From: Nicola Spencer on behalf of Planning.Responses
Sent: 05 February 2018 10:20
To: Karen Garner
Subject: FW: Fw: FG/115/17/PL 4 bungalows 44 ferringham Lane, Ferring
Attachments: 628-02 D.pdf; 628-03 D.pdf; 628-04 D.pdf

From: Anita Gardner <Anita.Gardner@arun.gov.uk>
To: [REDACTED]
Sent: Tuesday, January 23, 2018, 5:49:21 PM GMT
Subject: FG/115/17/PL 4 bungalows 44 ferringham Lane, Ferring

I refer to the above application. County Highways have responded to the latest consultation on this application relating to the revised dwelling positions by stating

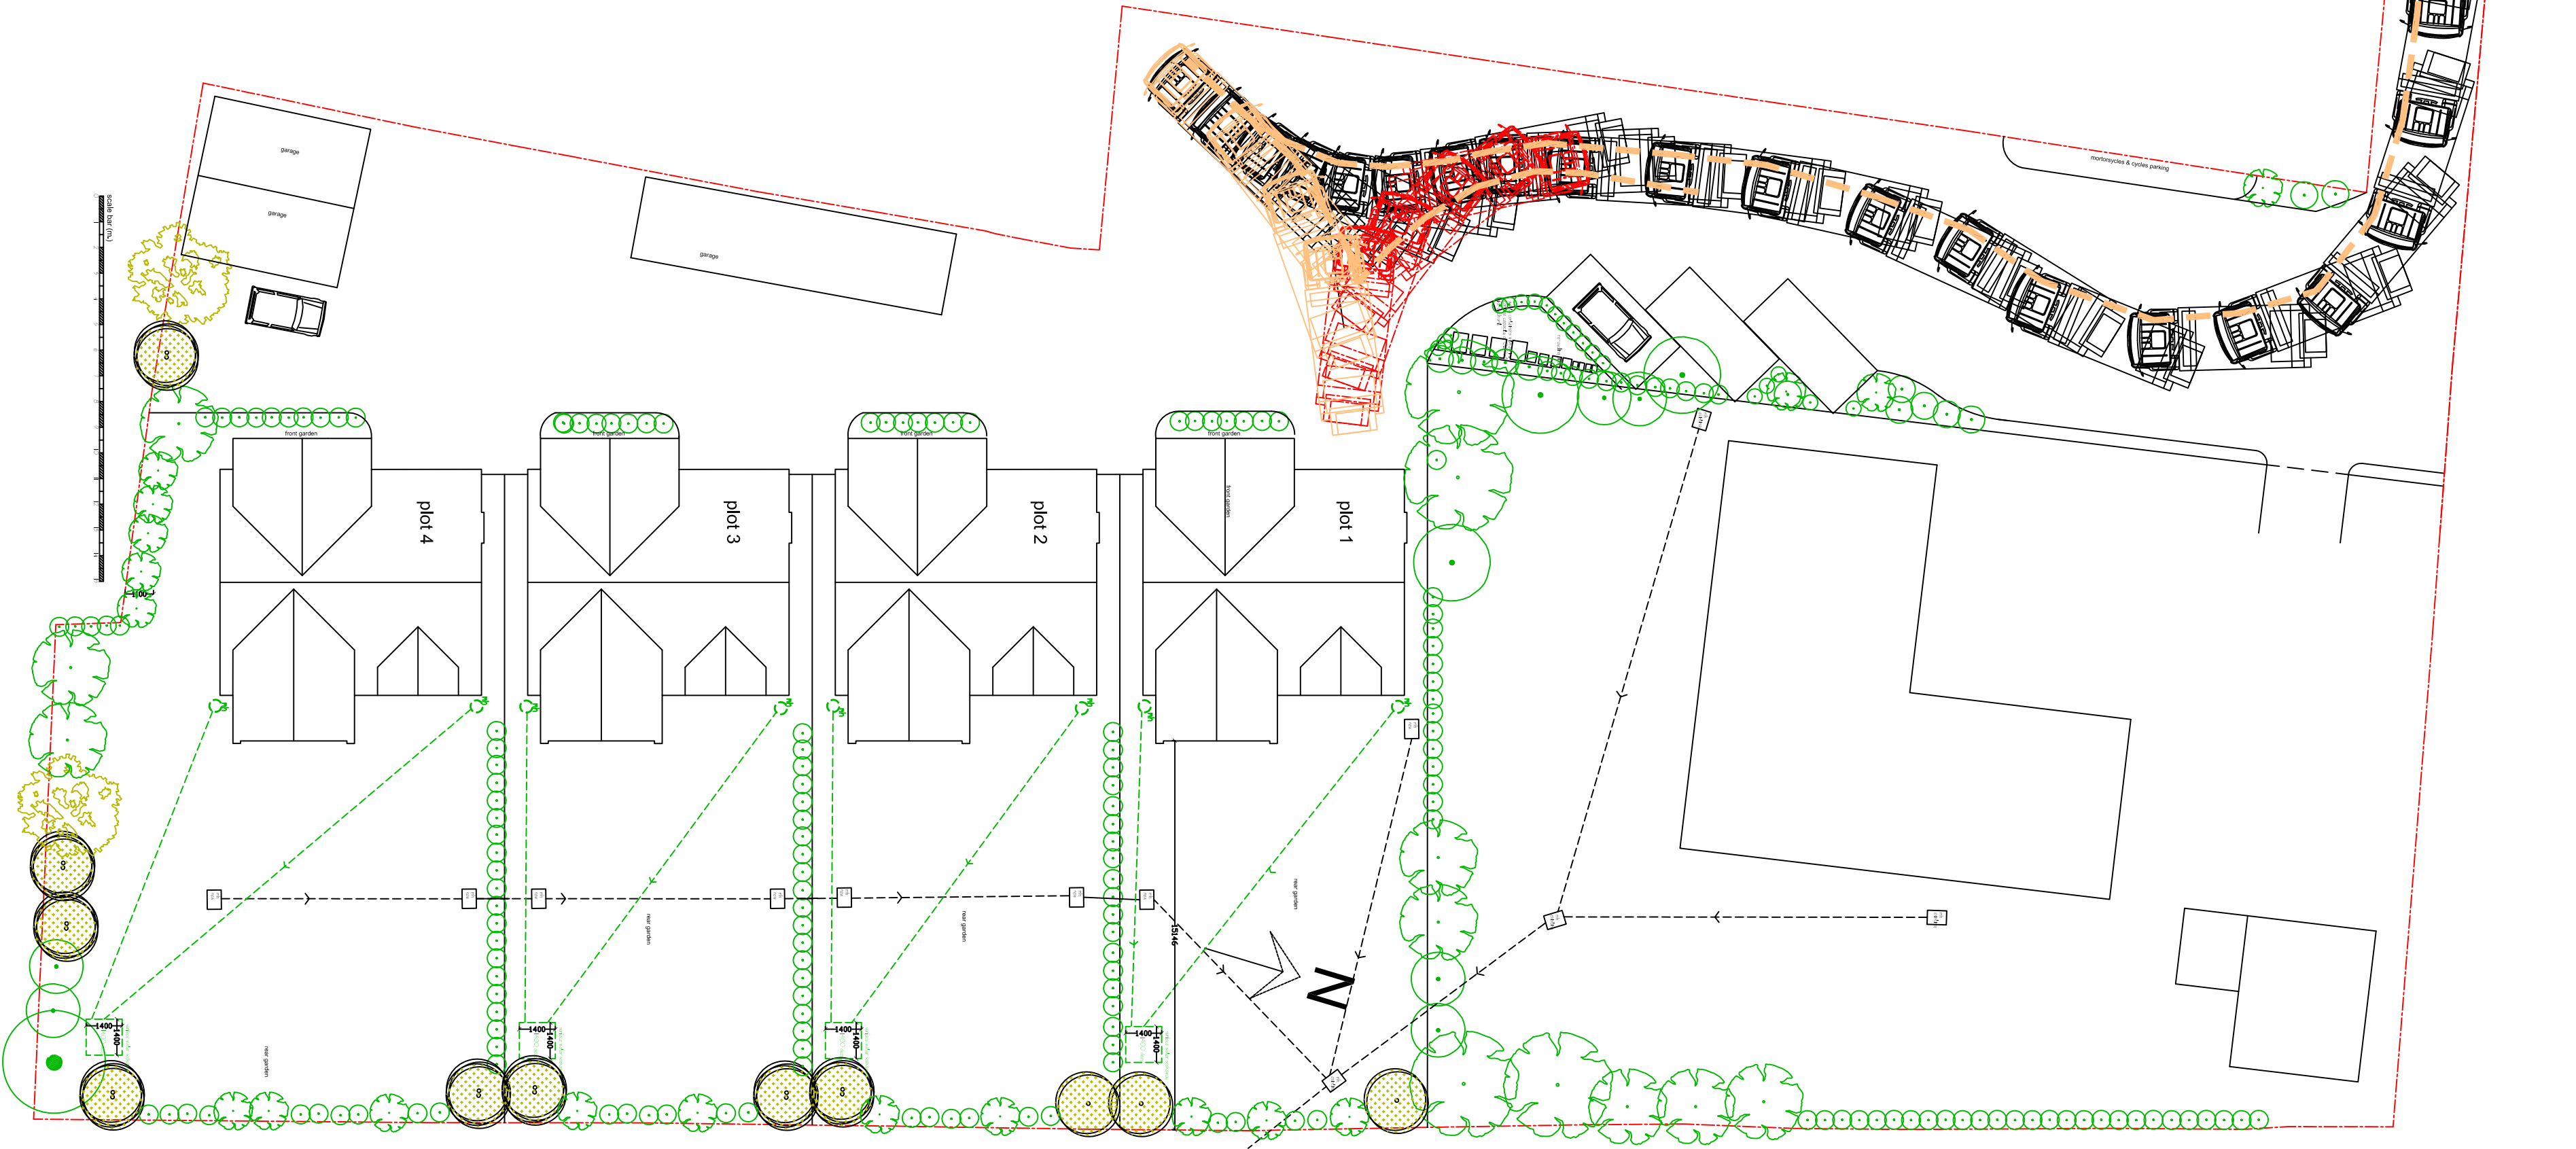
"The repositioning of the dwellings may impact the ability for larger vehicles (Fire and Refuse) to turn on site. Swept path tracking plans should be provided to demonstrate that the ability for larger vehicles to turn on site has been retained. This turning area should not use any area allocated for resident parking."

Please find attached dwg. nos. 628-02 Rev. D ,628- 03 Rev. D & 628- 04 Rev. D addressing the Swept Path Tracking. In doing so we had to slightly revised the visitors parking area.
